## **Advice to decision maker on Tahmoor South coal mining project**

### **IESC 2019-101: Tahmoor South Coal Project (EPBC 2017/8084; SSD 8445) – Expansion**

<b>Requesting agency</b>	The Australian Government Department of the Environment and Energy and The New South Wales Department of Planning and Environment
<b>Date of request</b>	21 January 2019
<b>Date request accepted</b>	24 January 2019
<b>Advice stage</b>	Assessment

Figure 3.1
Tahmoor South Proposed Mine Plan

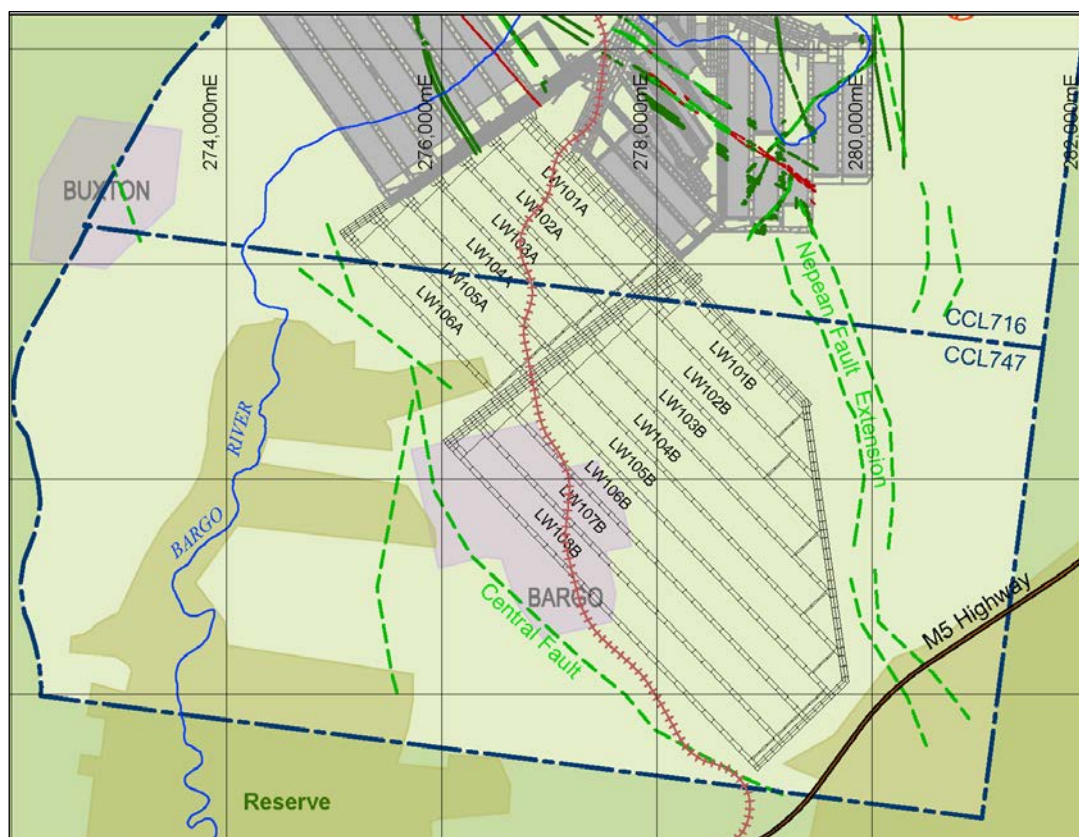
- Consideration should be given to reducing impacts of connective fracturing above the longwall and reducing surface cracking and near-surface fracturing on creeks and associated GDEs by additional alterations to the mine plan. This could be accomplished, for example, by altering the longwall placement or orientation so that creeks are not undermined or by other alterations to the mine design and geometry of panels and pillars.
